Appeal Decision

Appeal Ref: APP/Z4718/W/24/3342239

14 Thornhill Park Avenue, Dewsbury WF12 0DA

PROPOSED GROUND FLOOR
1:50

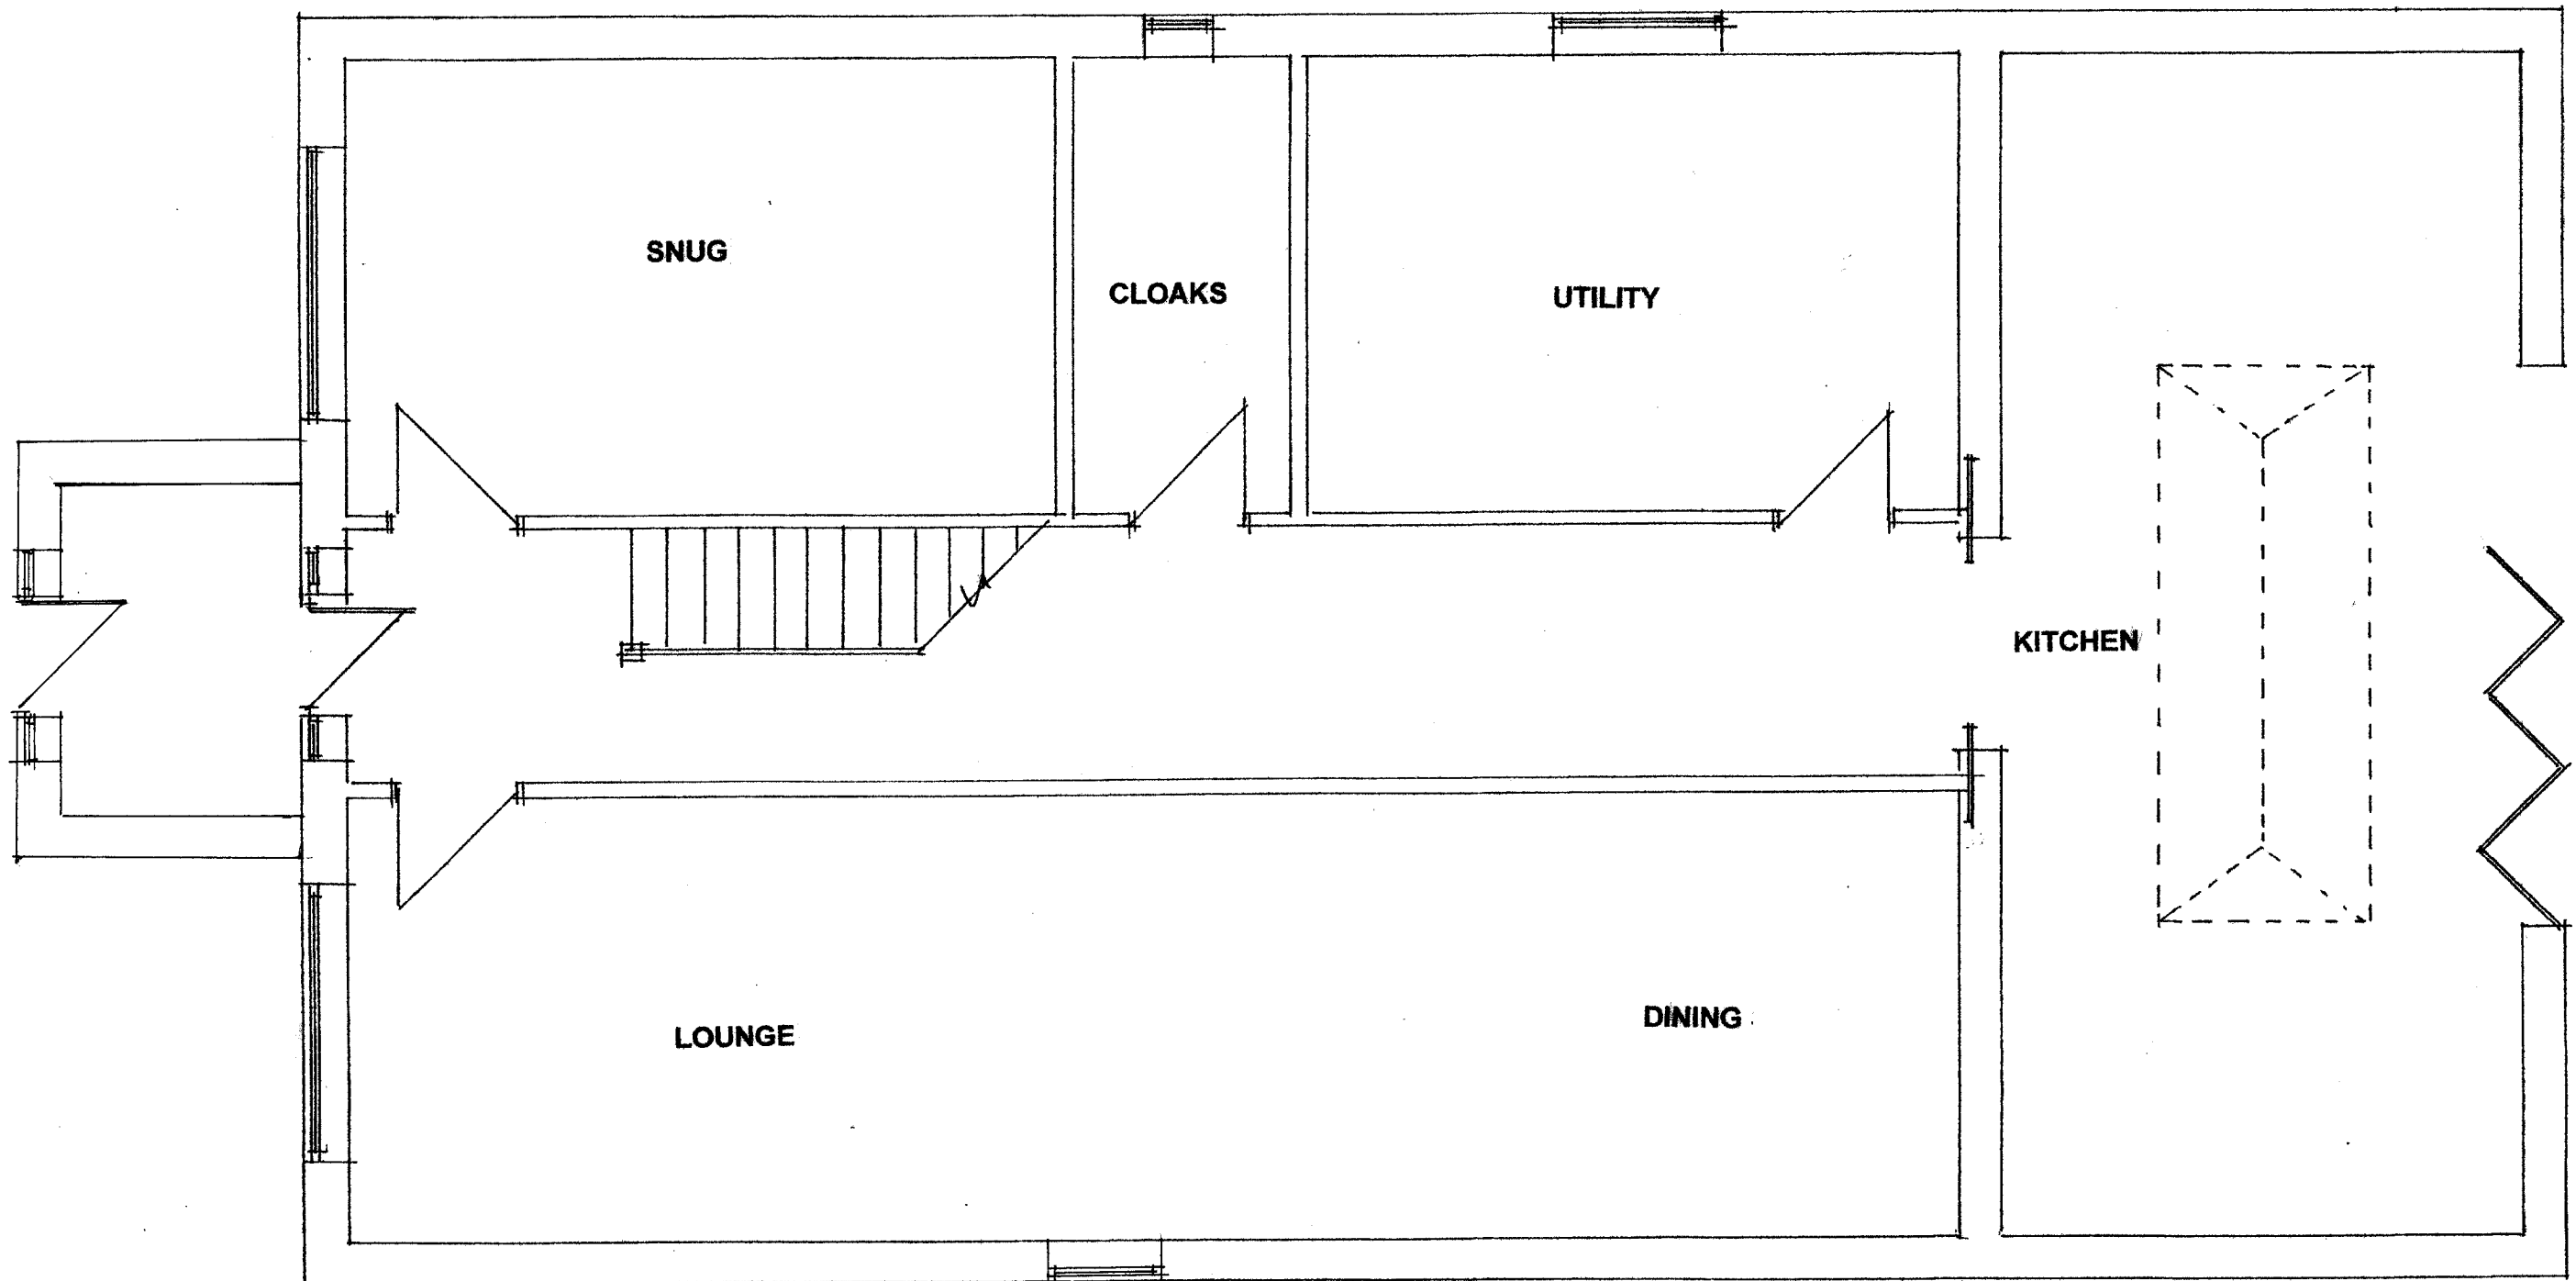
14. During my site visit there was no boundary treatment between the properties, and this is not indicated on the submitted plans. Depending on the details of this there may also be a loss of privacy for the occupiers of No 12.

PROPOSED SIDE ELEVATION
1:100

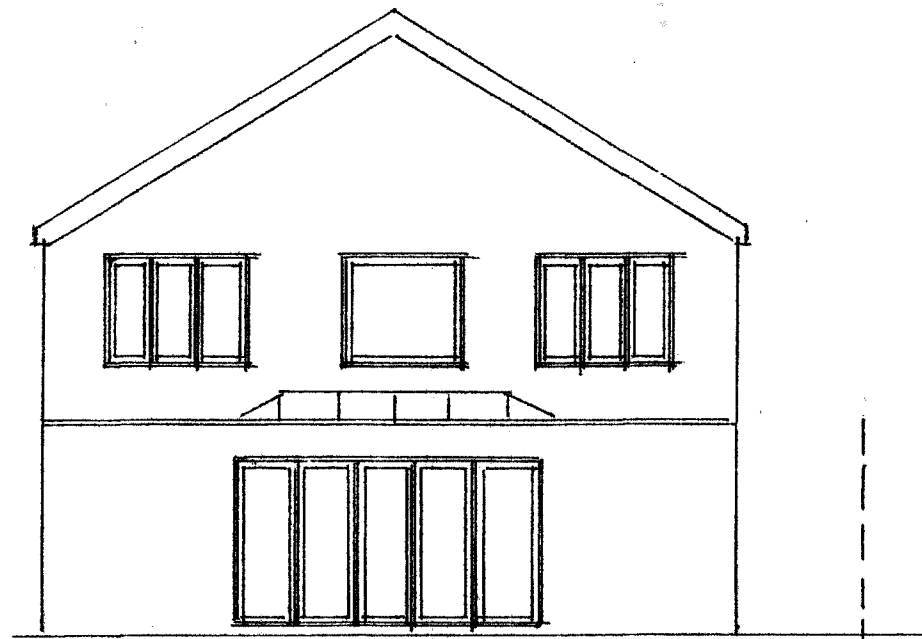
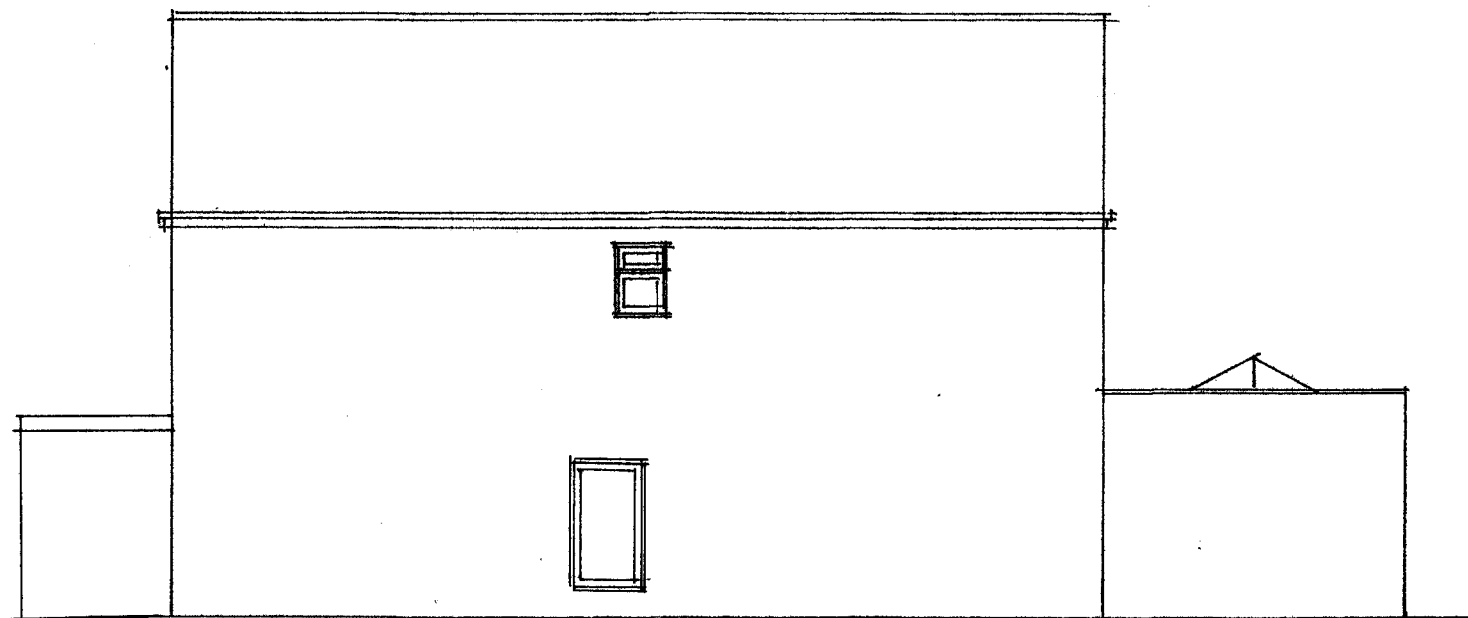
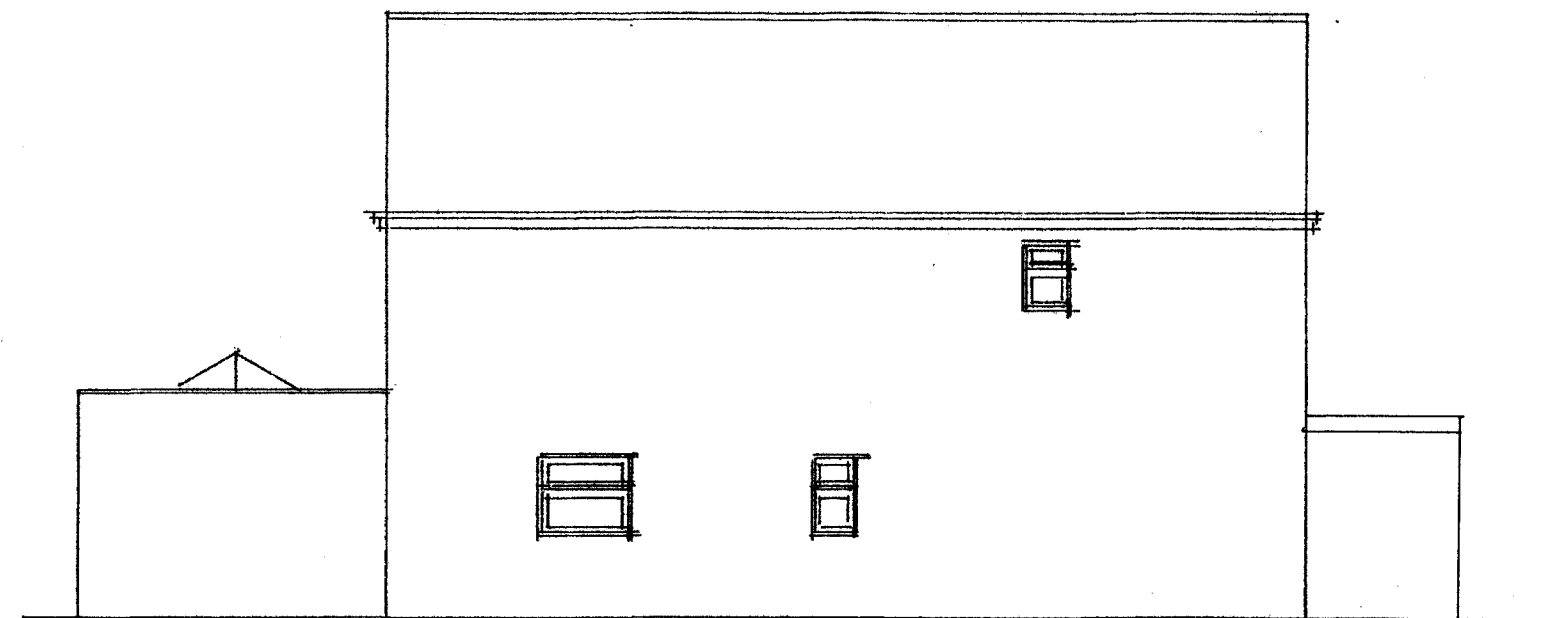
8. Planning permission had been granted for single and two-storey extensions to the former building. However, the new dwelling is significantly larger than the scale and massing of the original dwelling even with these approved extensions. The new dwelling has a similar footprint in terms of width to the previous dwelling, but as this is now gable fronted, its overall bulk and massing appears much greater. As a result, it appears incongruous alongside the other more modest two-storey dwellings in the cul-de-sac. As its depth extends much further to the rear it creates a large expanse of flank wall, which further exacerbates its bulky appearance.

9. The development has a single roof span running across the whole two-storey element, with a single-storey section to the rear. This creates an expansive area of roof which appears discordant within the street scene, interrupting its uniformity.

13. The new dwelling has a single roof span running across the whole two storey element, which is less than 2.5m from the side elevation of No 12. The overall scale and close proximity with No 12, has an oppressive impact on this modest bungalow. In addition, No 12 has a window on the side elevation facing the replacement dwelling, serving a bedroom, which is a habitable room. I note that this window has been inserted as part of a recently approved single storey rear extension. The two-storey element of the new dwelling extends further to the rear than the original property so that this window now faces directly onto its side elevation. The proximity of the two-storey element of the replacement dwelling results in an unacceptable loss of daylight to this habitable room.
